Application No: P/161/21/HH
Site Address: 21 Pyrford Close Pagham PO21 3NL
Description of works: Erection of single storey rear extension, front porch, detached garage to side, shed in rear, conversion of loft to habitable use and alterations to fenestration/openings following the demolition of existing rear conservatories.

Thank you for your internet representation made on 22nd December 2021 which has been recorded as an objection with the comments as follows:

OWPC42838

Sheet
Plans and Elevations as proposed

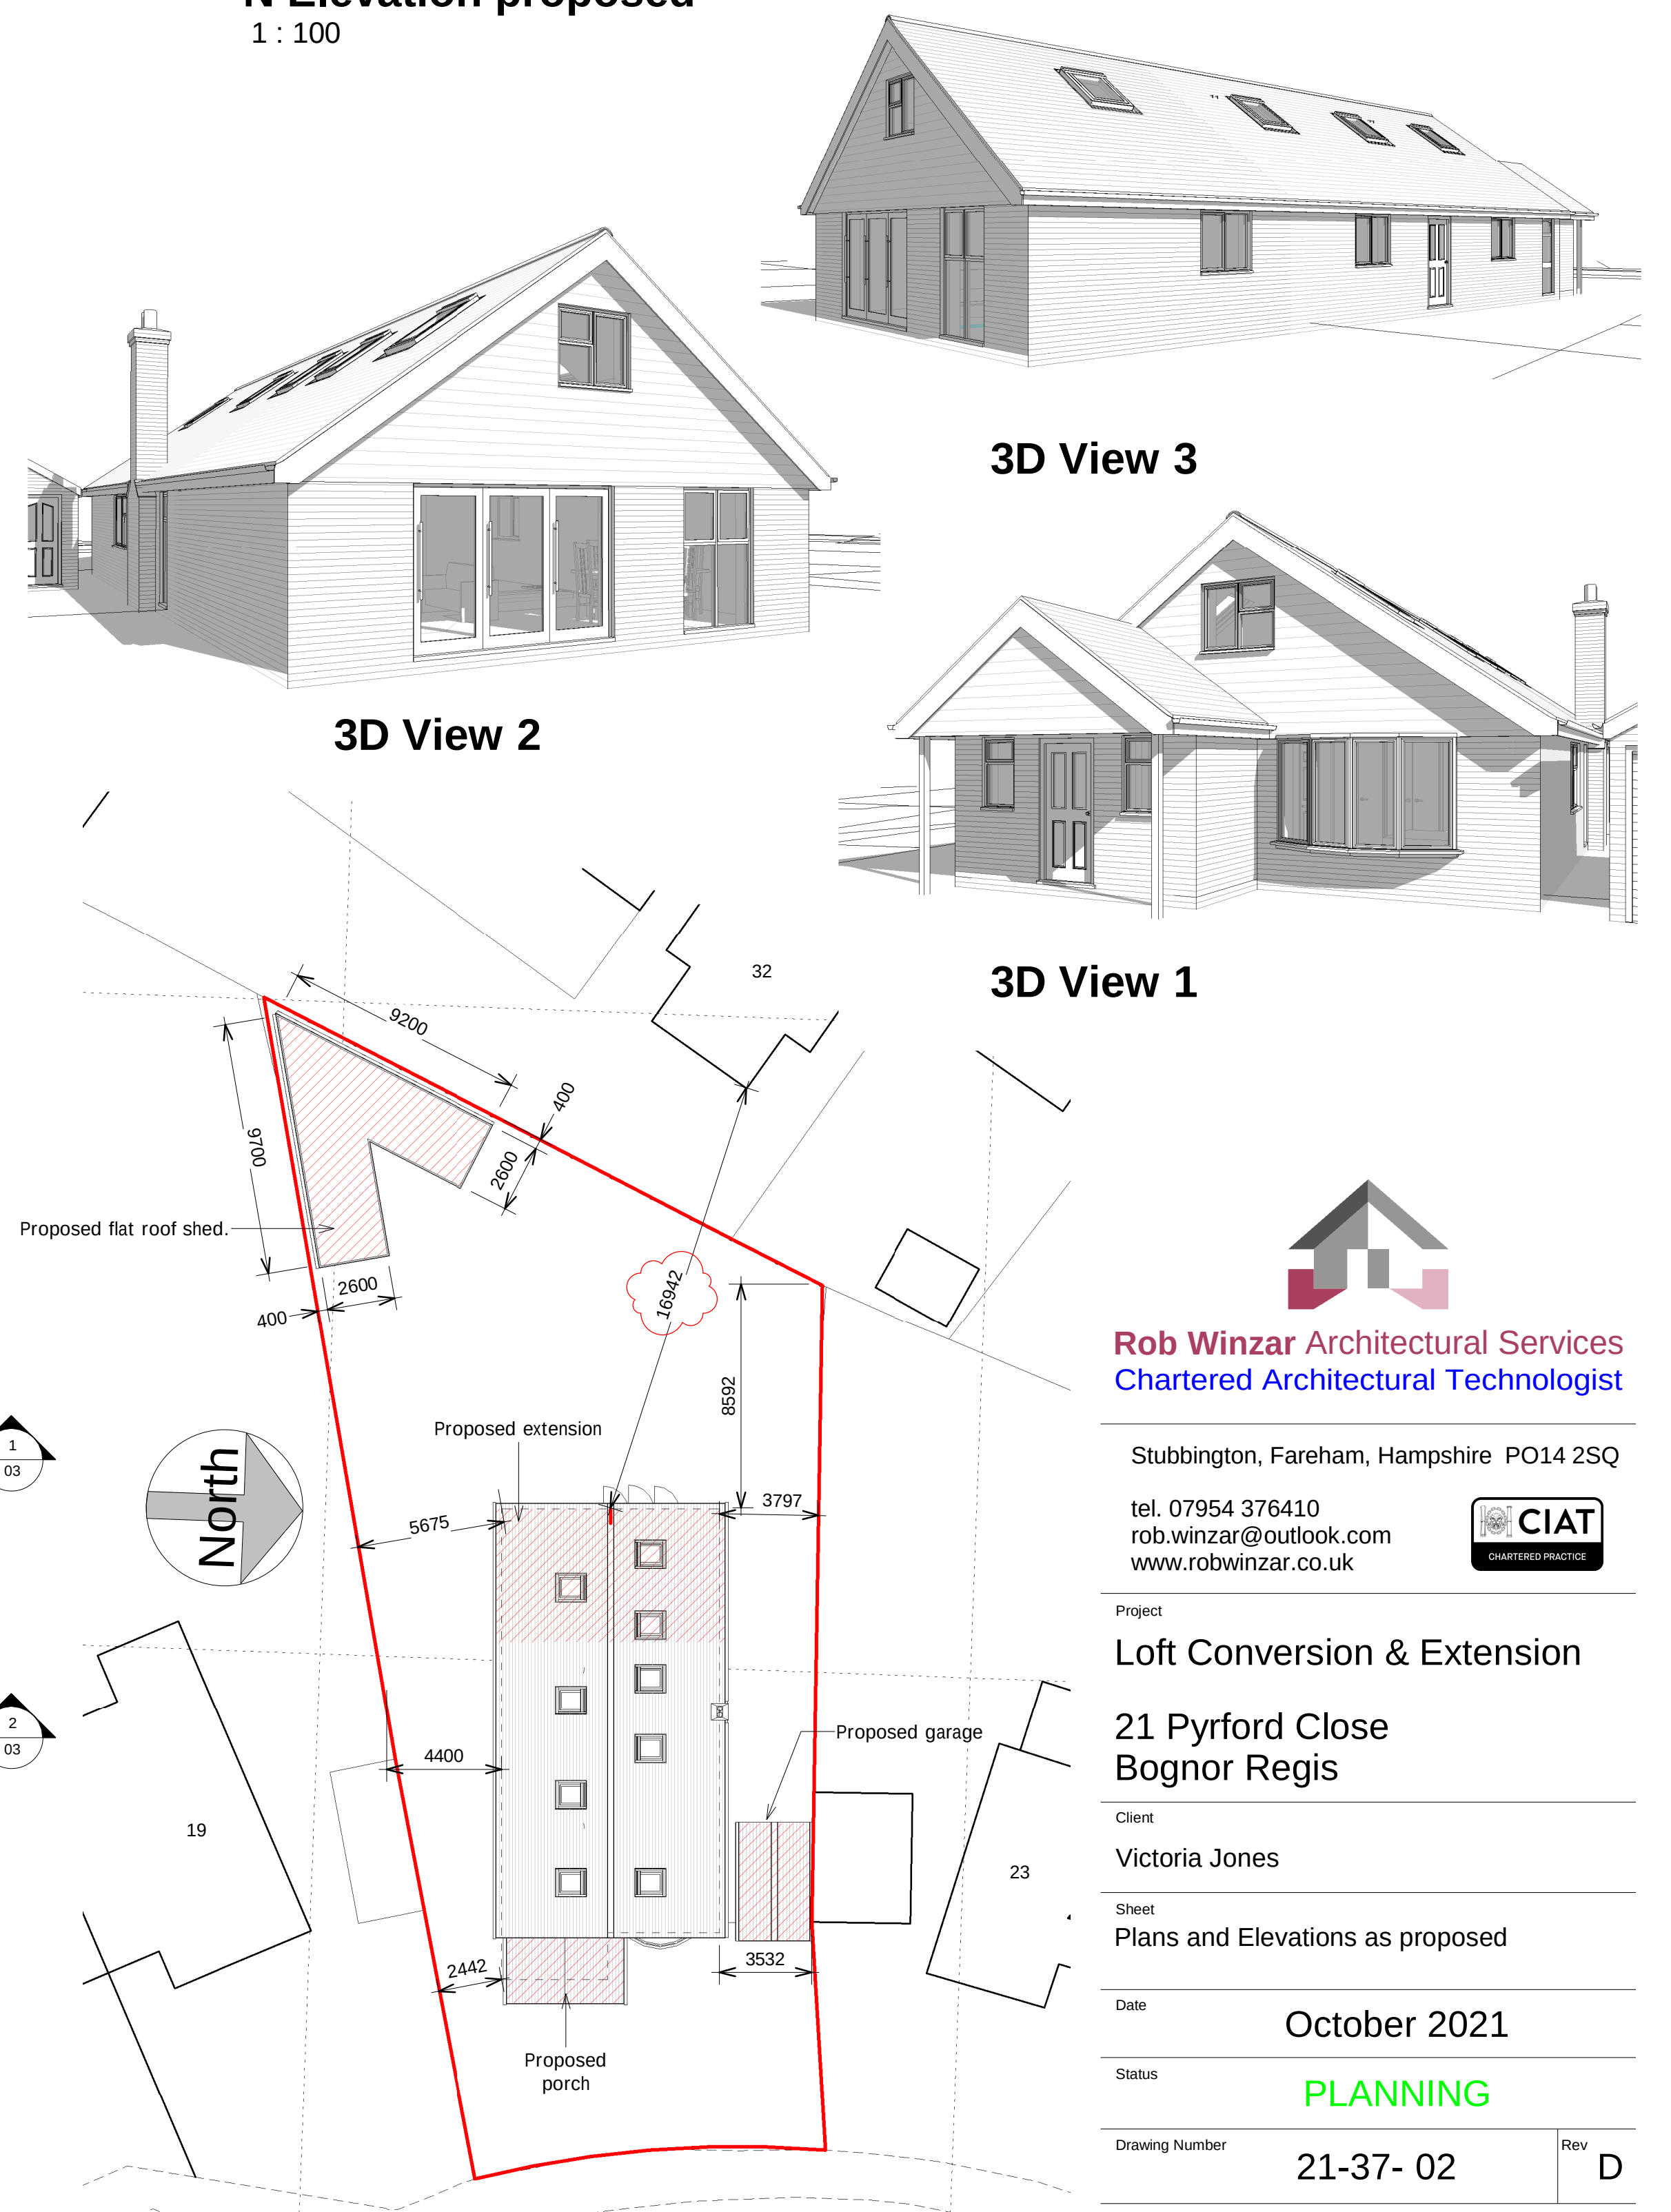
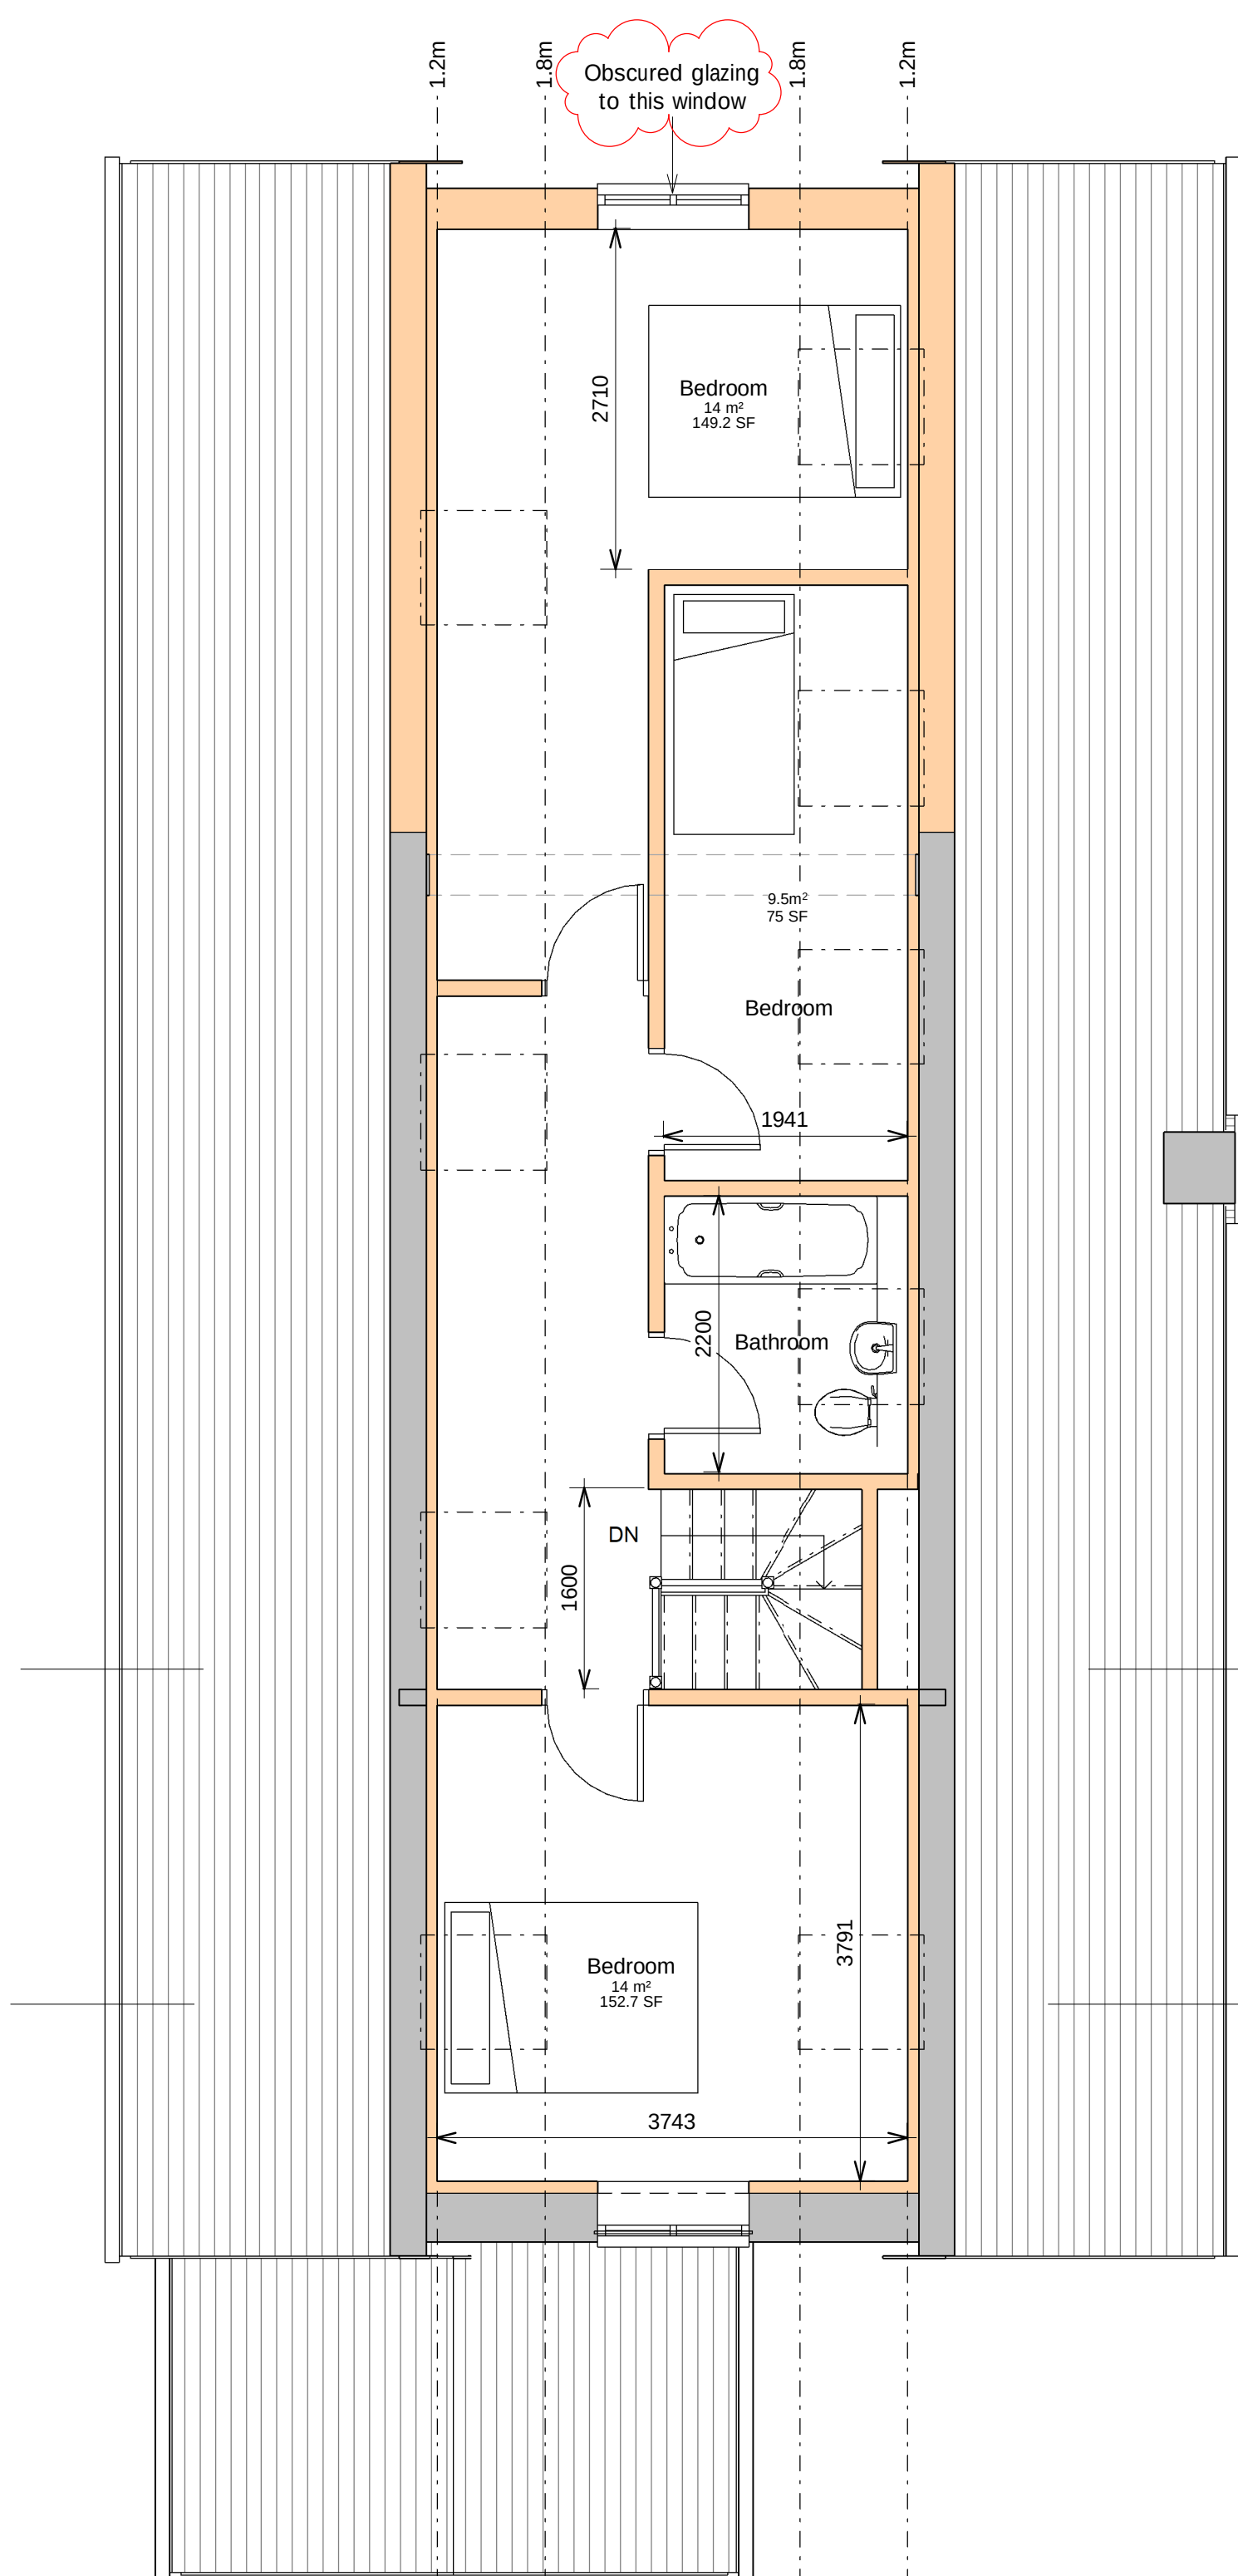
Our objection is against the proposed 'Garden Shed'. The main reason is the size and scale of it. It seems very excessive for a garden shed. The overall height of 2.55 metres, in our view, over exceeds the height of any normal flat roofed garden shed. It also means that 2.5ft of the wall and roof of this will be visible over our fence. It's bigger than the proposed garage wall height? It will overshadow one side of our garden and block out light.

We are concerned about what the shed is going to be used for and potential noise from it as a standard garden shed does not have patio doors nor is it to this scale. There are also no mentions of materials being used on the outer skin which will be on total view when we look into our garden.
